From: Vanessa Clipstone <Vanessa@laister.co.uk>
Sent: 14 November 2023 12:09
To: Tom Nemeth
Cc: Jo Bell; Nayan Gandhi
Subject: [EXTERNAL] RE: Medmerry Masterplan - Hybrid Planning Application (reference E/23/01967/FUL). Additional Validation Requirements.
Attachments: 1096 S 231114 Medmerry Masterplan Application Drawings and Documents Schedule updated.pdf

Subject: RE: Medmerry Masterplan - Hybrid Planning Application (reference E/23/01967/FUL). Additional Validation Requirements.

The following drawings will require amending:-

Sheet Number: 427.01_2500.4 Rev: P2

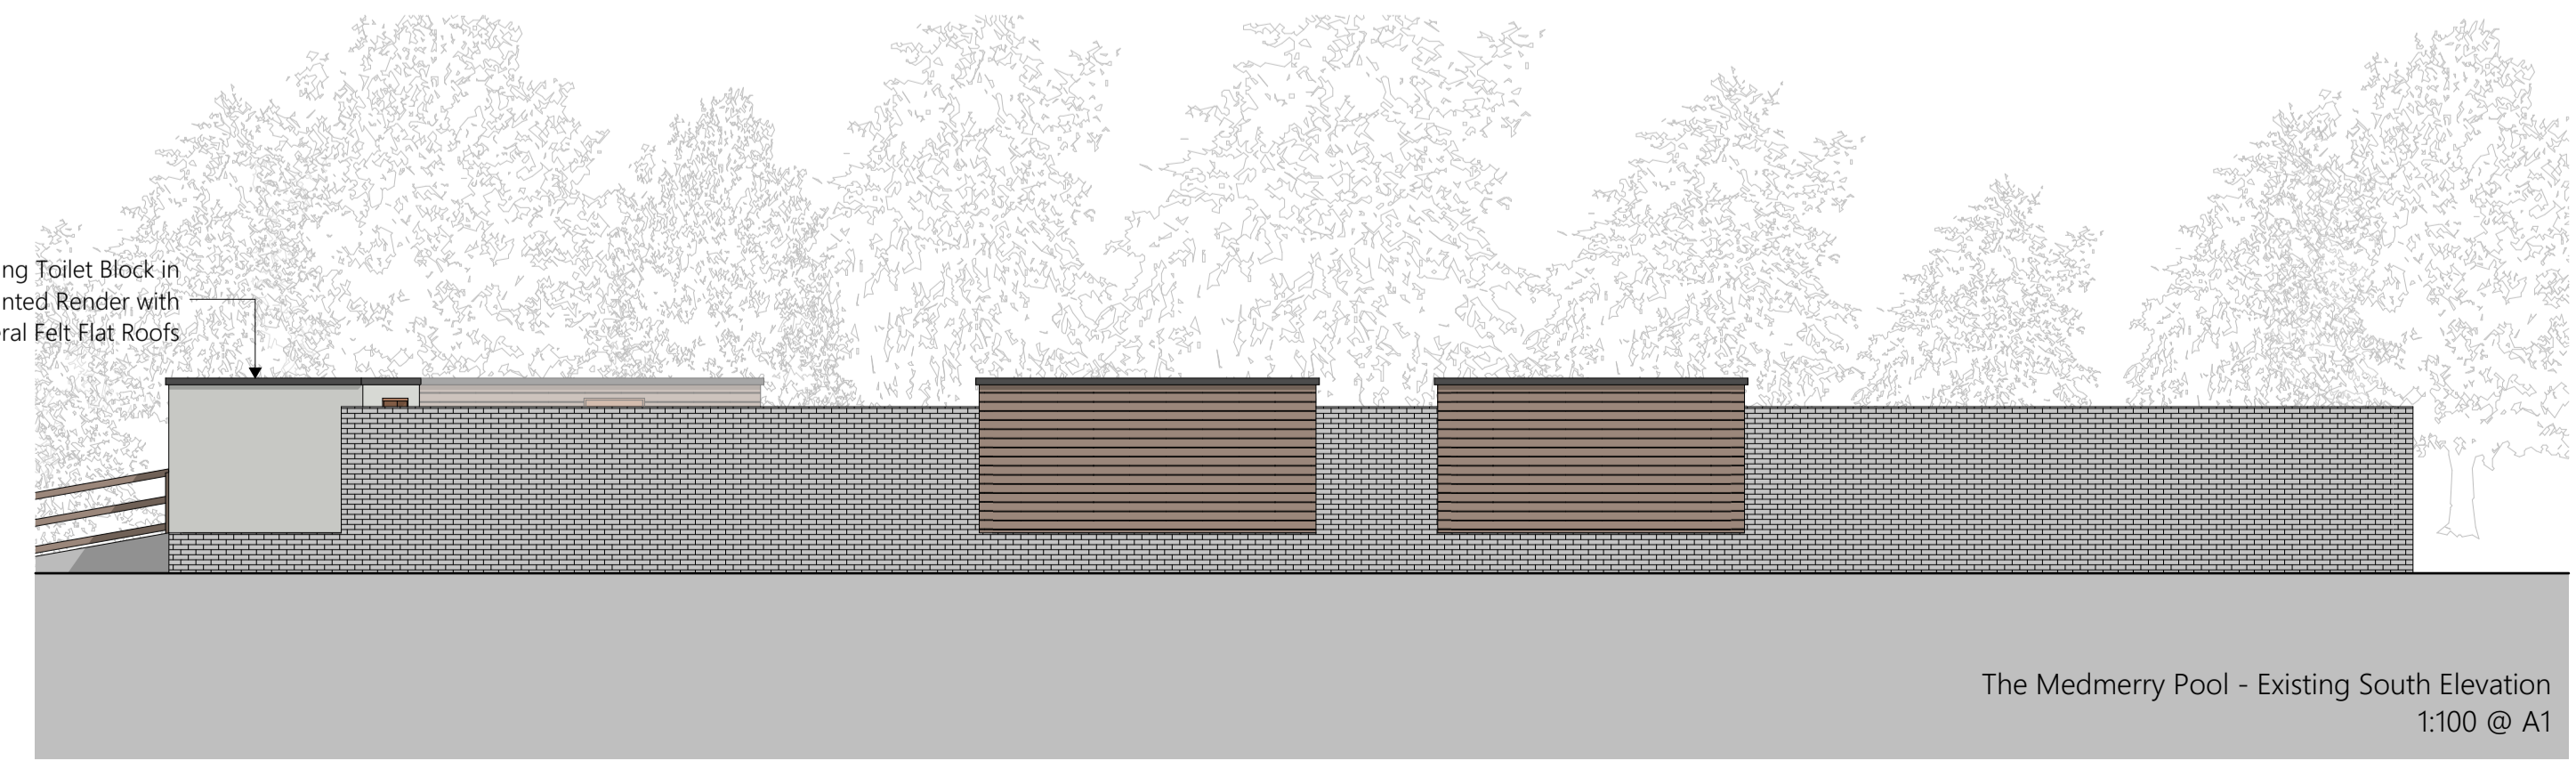
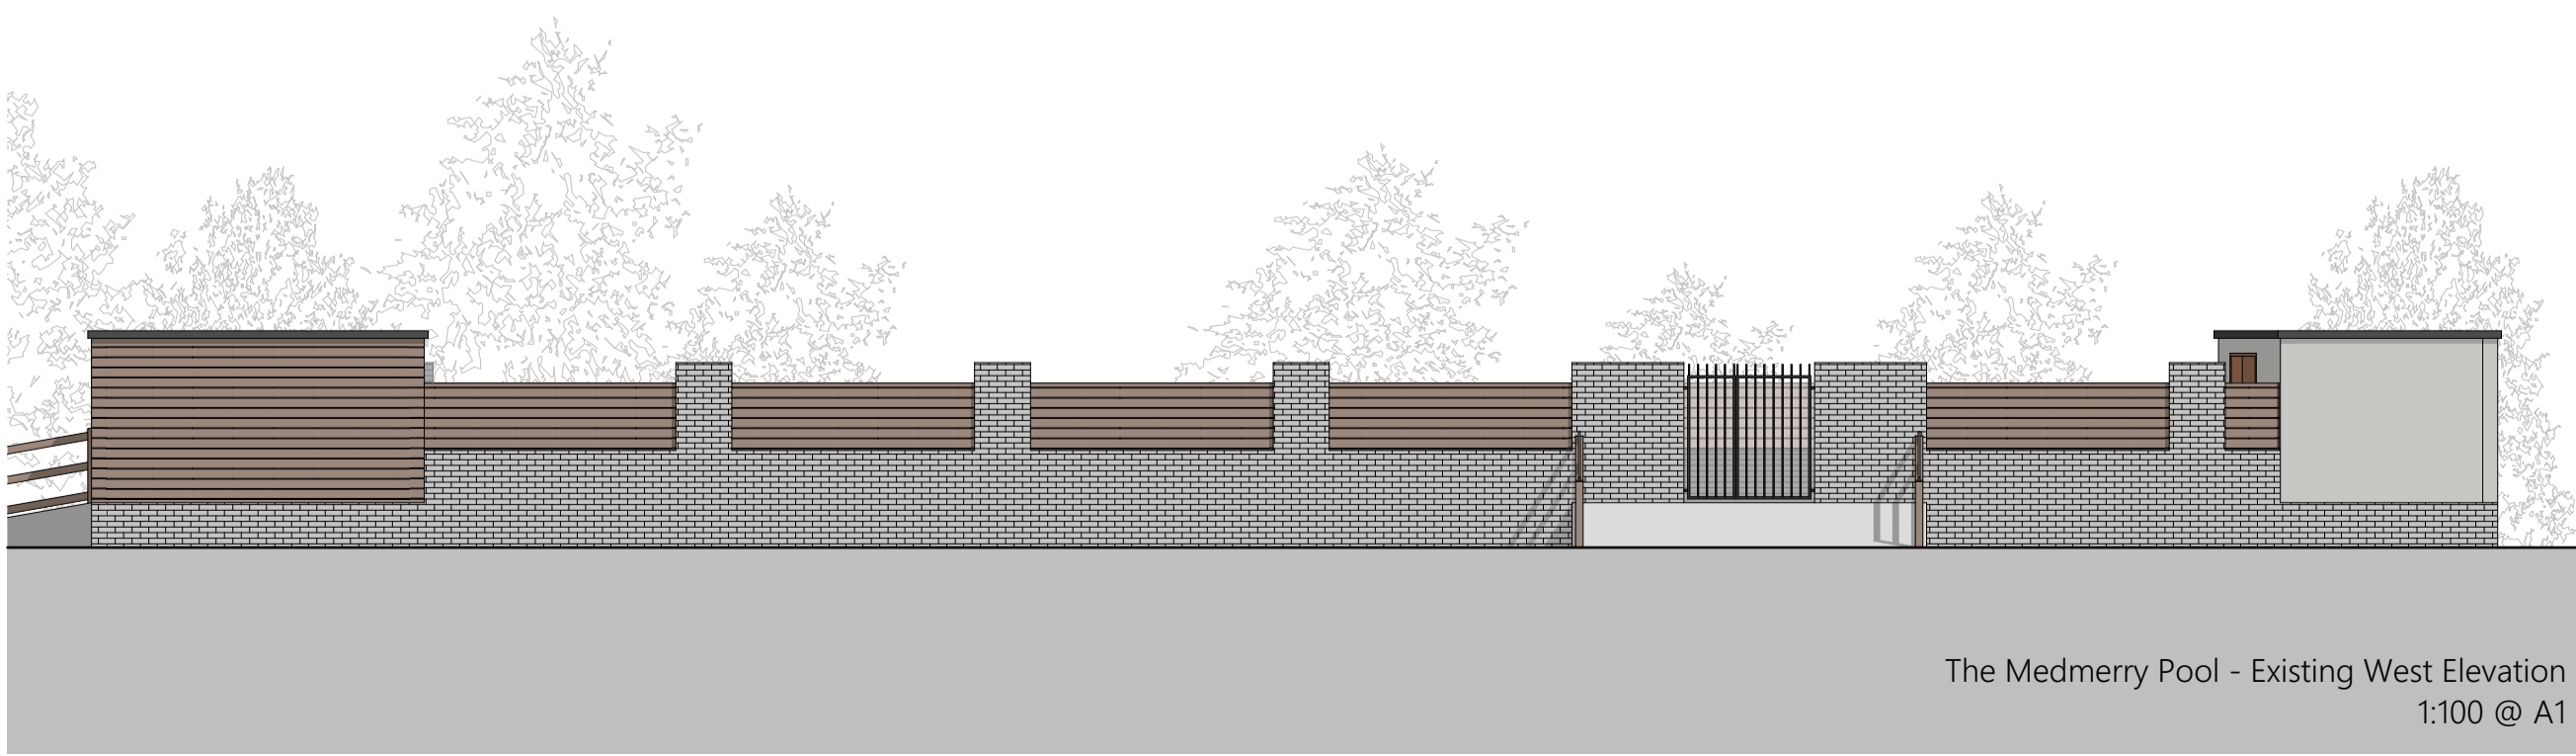
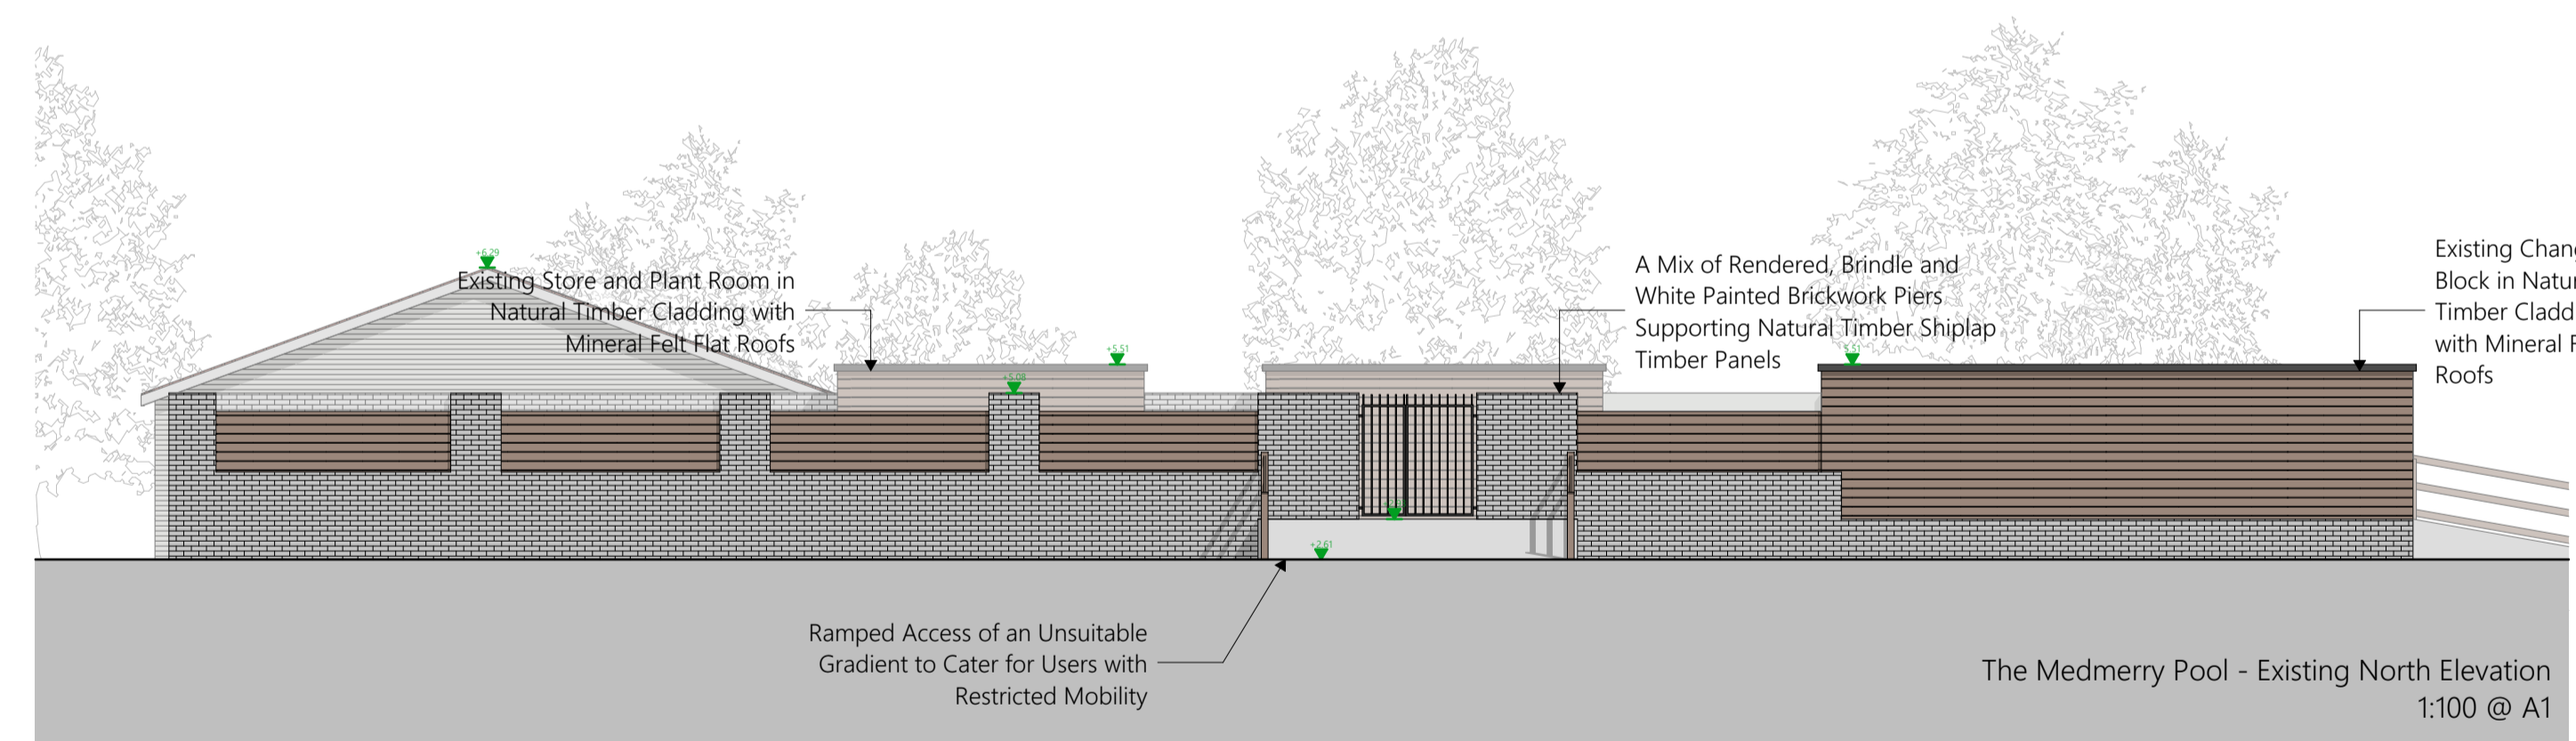
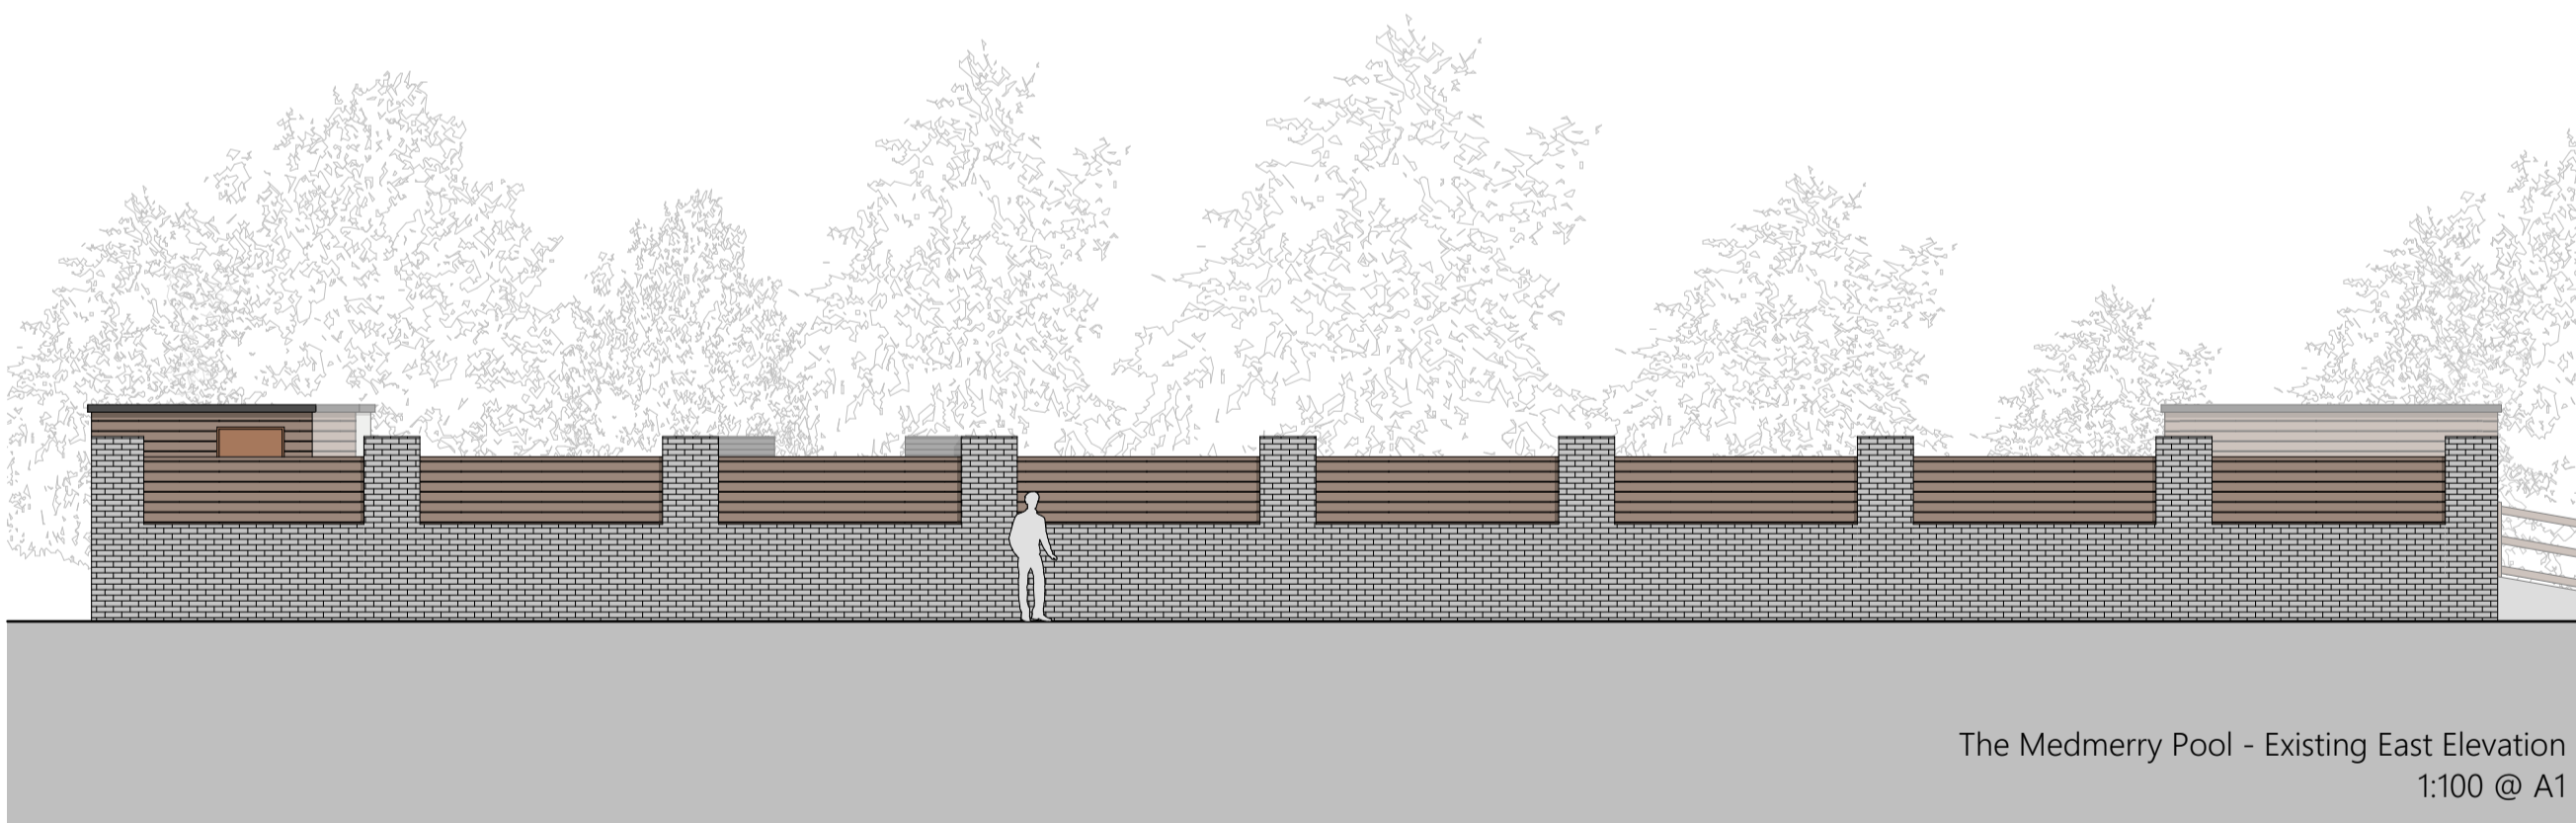
427.01_2500.4 REV P2 - The Medmerry Pool Existing Ground Floor Plan and Elevation

Existing Ground Floor Plan states 1:100 but has a scale bar measuring 1:200.

- 427.01_2300.4 REV P2 – The Medmerry Village Existing Ground Floor Plan - increments added to the scale bar
- 427.01_2300.6 REV P2 - The Medmerry Village Proposed Ground Floor Plan - increments added to the scale bar
- 427.01_2500.4 REV P2 - The Medmerry Pool Existing Ground Floor Plan and Elevation - scale bar updated to 1:100.
- 427.01_2500.5 REV P2 - The Medmerry Pool Proposed Ground Floor Plan and Elevation - scale bar updated to 1:100 and drawing now includes images
- DWG/4105/001 REV B - Swept Path Drawings – 1:2000 scale bar included.
- DWG/4105/002 REV B - Swept Path Drawings - 1:2000 scale bar included.
